From: Anna Harper [REDACTED]
Sent: 23 October 2019 15:14
To: Simon Davis <Simon.Davis@arun.gov.uk>
Subject: RE: [EXTERNAL] Fwd: Site 6, Chichester Road, Bersted ref BE/84/19/PL

Status
for planning
Scale
1:200@A1
Job number
1526
Drawn
AR
Drawing number
L90-201
Date
Aug 2019
Revision
A

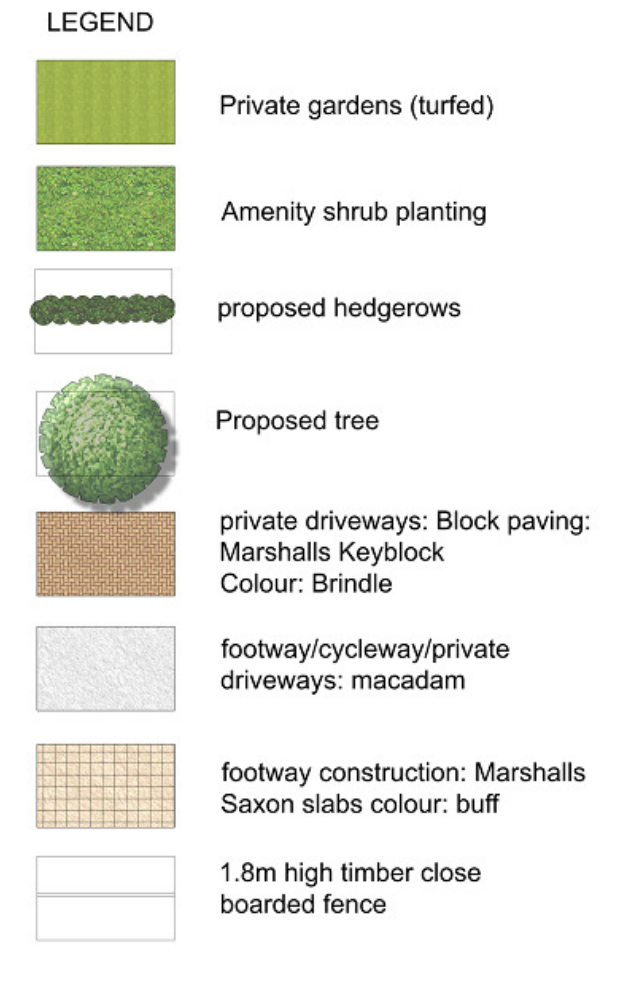
I have been looking at the hedge on Google Streetview (dated to June 2018) and this clearly suggests that the hedge is wider than the 2m width shown on your landscape plan. I estimate (using a brick length of 22.5cm) that the section above the brick wall in the attached photo is around 2.25m. The image suggests the hedge is at least double this. Also, I note that the streetview imagery suggests that the hedge is not a perfect straight line as per your drawing.

have amended plans been submitted yet to show the correct width of the landscape hedge and also that it is NOT to be included within the curtilage of any property but is fenced off separately and remains the responsibility of the management company to maintain as currently occurs along with the rear hedge

In addition the submitted drainage plan appears to show the removal of the corner of the landscape where the side and rear parts meet - this is unacceptable. i do not see why it needs 4 spaces and if 3 are required one could be adjacent to the garage.

This plot should also be moved 1.5m to the west to provide a 1.5m gap between its side wall and the hedge. Experience shows that the hedge will be removed in part to get the scaffold in otherwise. There is room to move it to the west

drawing L90-201 Rev A seems to remain current but the drainage plan contradicts this plan

As just discussed, the landscape plan was updated and re-issued following Mr Jupp's comments so I am happy we have addressed that point.

The hedge viewed from Chichester Road appears as though it remains the same thickness the whole length. It does in fact kink in and thin in places along the boundary. As we have shown on plan, we are proposing the boundary be retained as is.

Mr Jupp has queried whether amended plans have been submitted yet to show the correct width of the landscape hedge. As discussed, I am content that the plan issued to you on Monday 16th September (Tree Plan JN283-2500) along with the updated landscape plan issued on 19th August 2019 address the matter of the existing hedge and that you have adequate information to determine on that basis.

It would be extremely impracticable for the hedge not to be included within the curtilage of any property. Not only would this cause future management issues, it would also create a potential rat run and unattractive frontage to Chichester Road. It is perfectly natural for a hedge to form the boundary to a curtilage, as it does to the property adjoining the site, so this is something we are not willing to look at implementing.

Lastly, Mr Jupp has quite rightly highlighted discrepancies between the proposed site layout and drainage strategy plan submitted. Can I suggest a drainage condition be imposed on this permission, given that we have not yet progressed to full detailed technical design this drawing has not yet been produced. If you feel it is required ahead of approval, I will of course instruct the work.
